Your Ref: SSD-37486043

## **OAKDALE EAST INDUSTRIAL ESTATE PUBLIC EXHIBITION OF EIS – FAIRFIELD COUNCIL SUBMISSION**

This submission responds to the NSW Department of Planning and Environment (DPE) notification regarding public exhibition of the Environmental Impact Statement (EIS) for the Oakdale East Industrial estate (SSD37486043). The proposal includes a concept masterplan and stage 1 works, intersection upgrades to local roads, bulk earthworks, internal roads, services, expansion of an existing warehouse in precinct 1 and construction and operation of a warehouse in precinct 3.

Title:
Change in Peak Flood Level - 1% AEP Flood

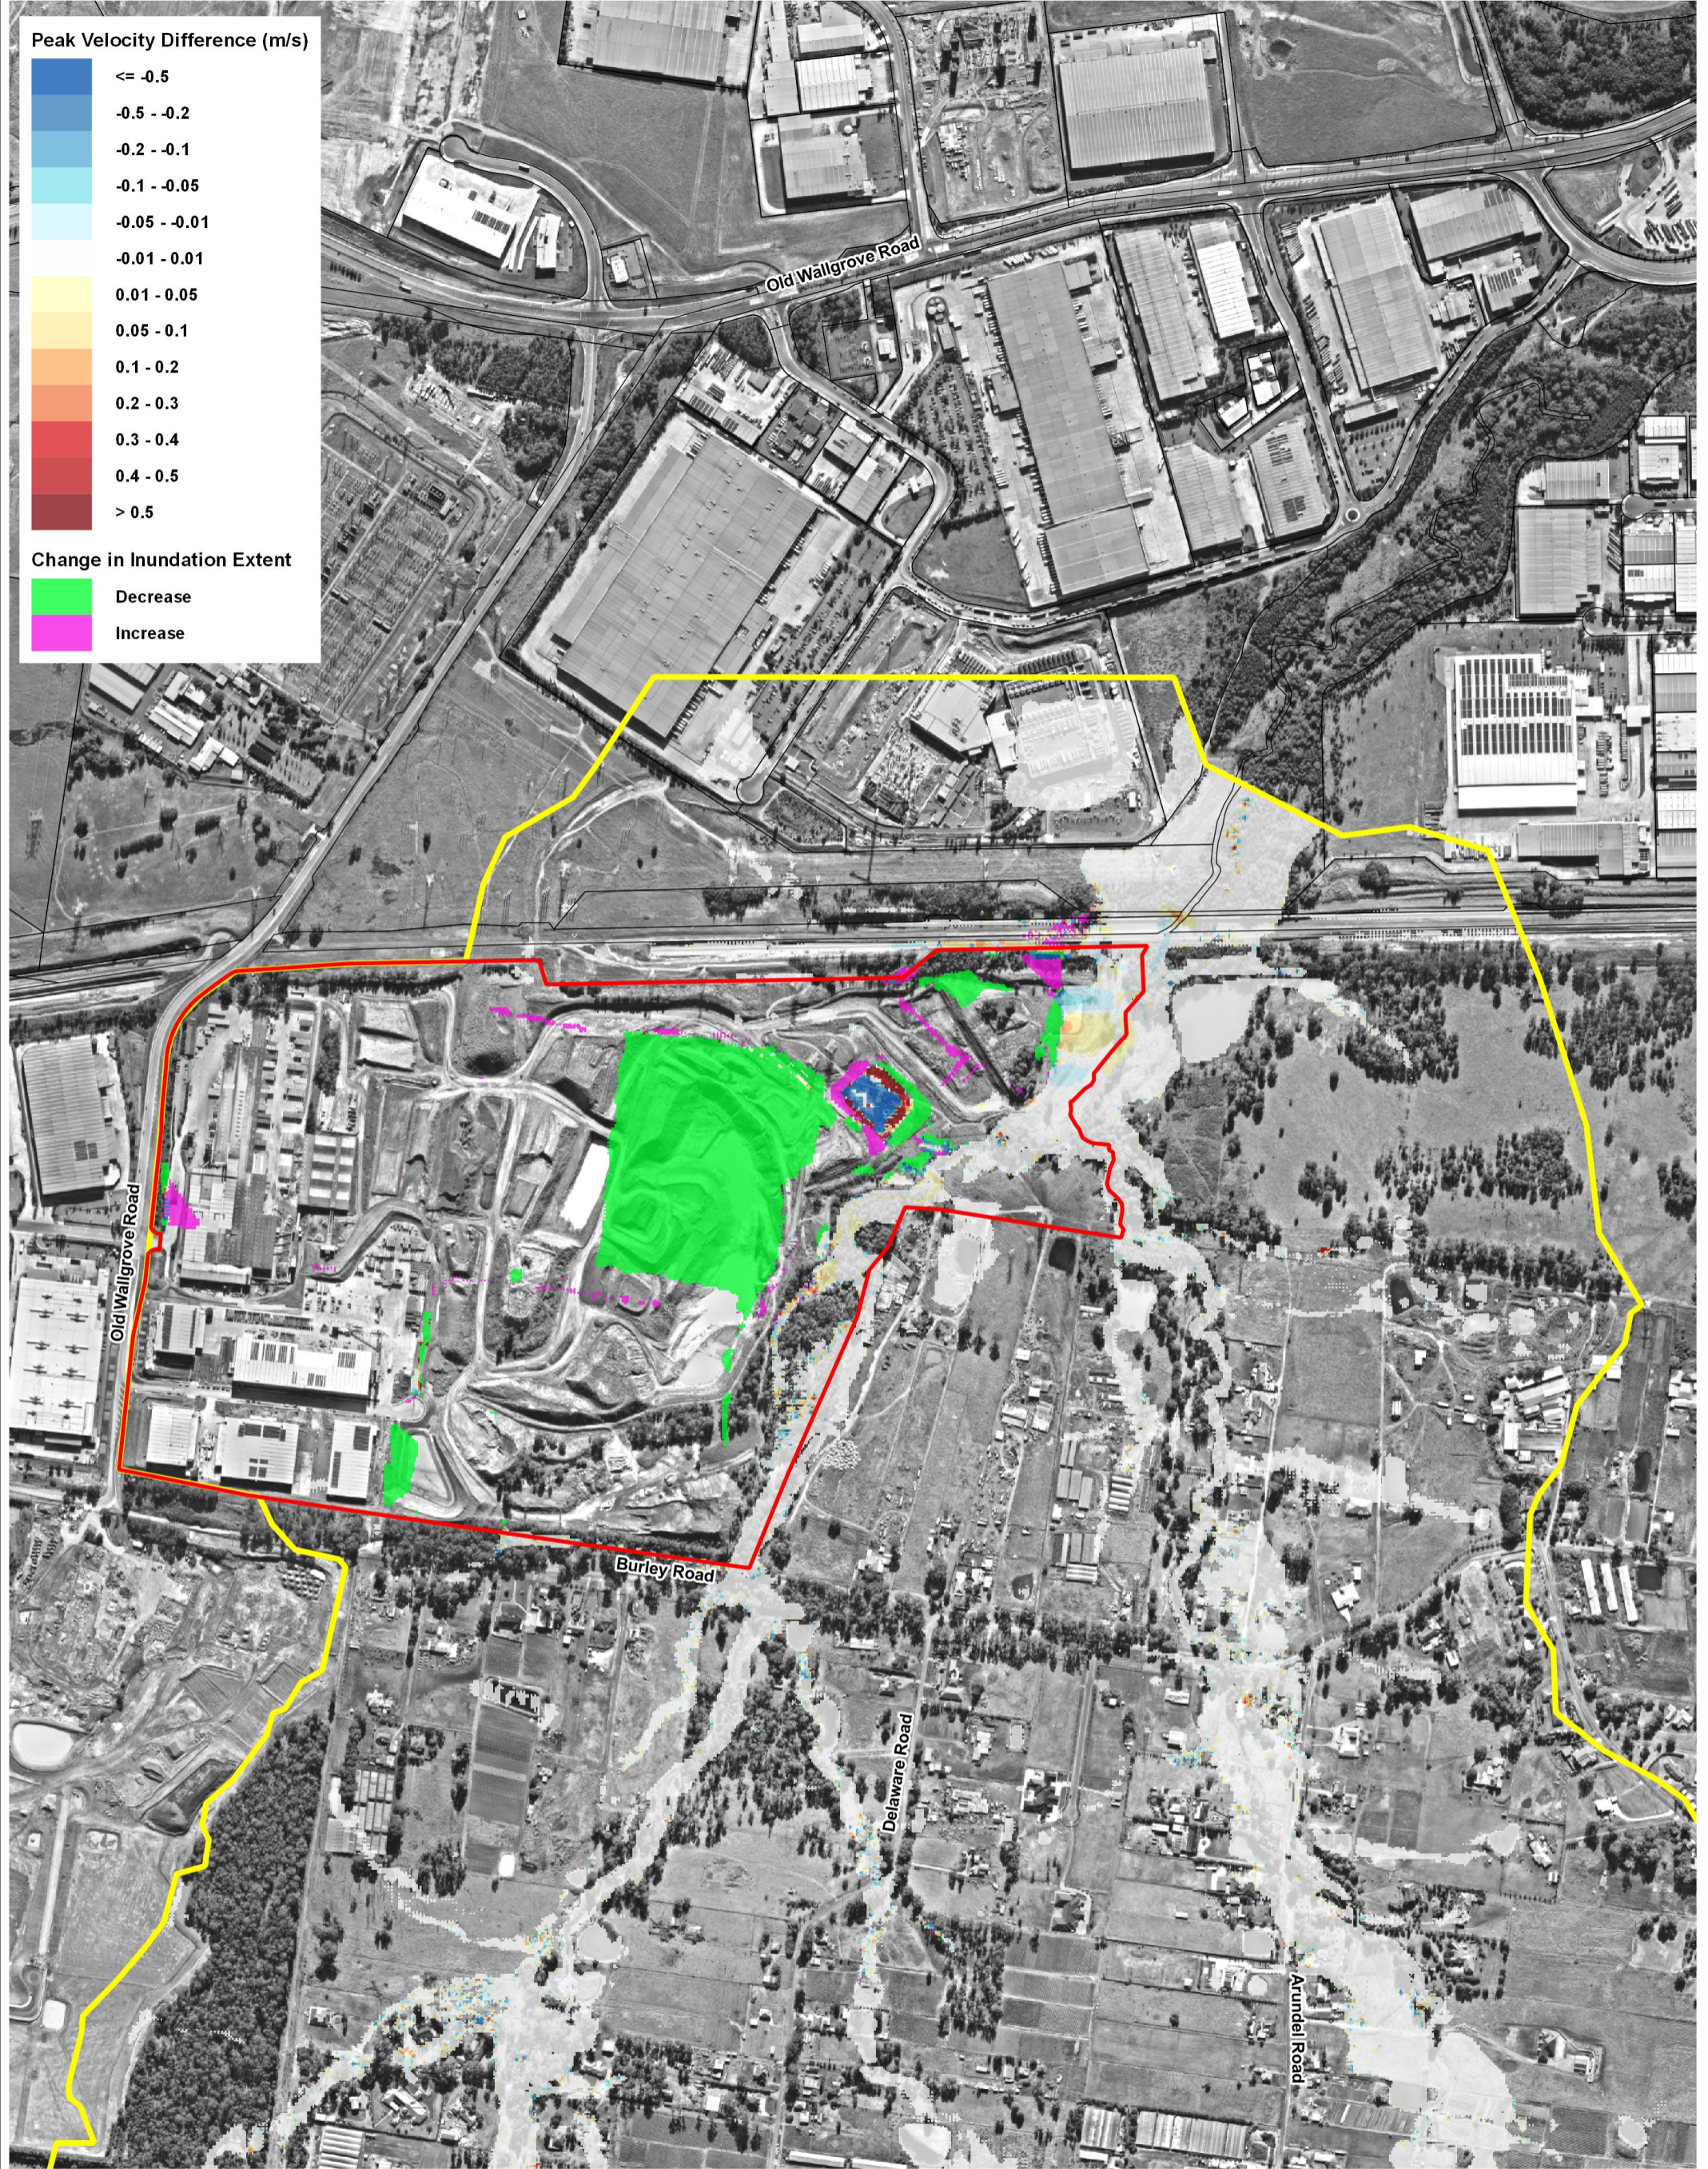
- A. Flood Impacts** – The development should have negligible impact on neighboring properties. Council defines this as no more than 0.01m afflux for the 1% AEP event. The EIS states that the afflux is 0.03m and as such is not acceptable.
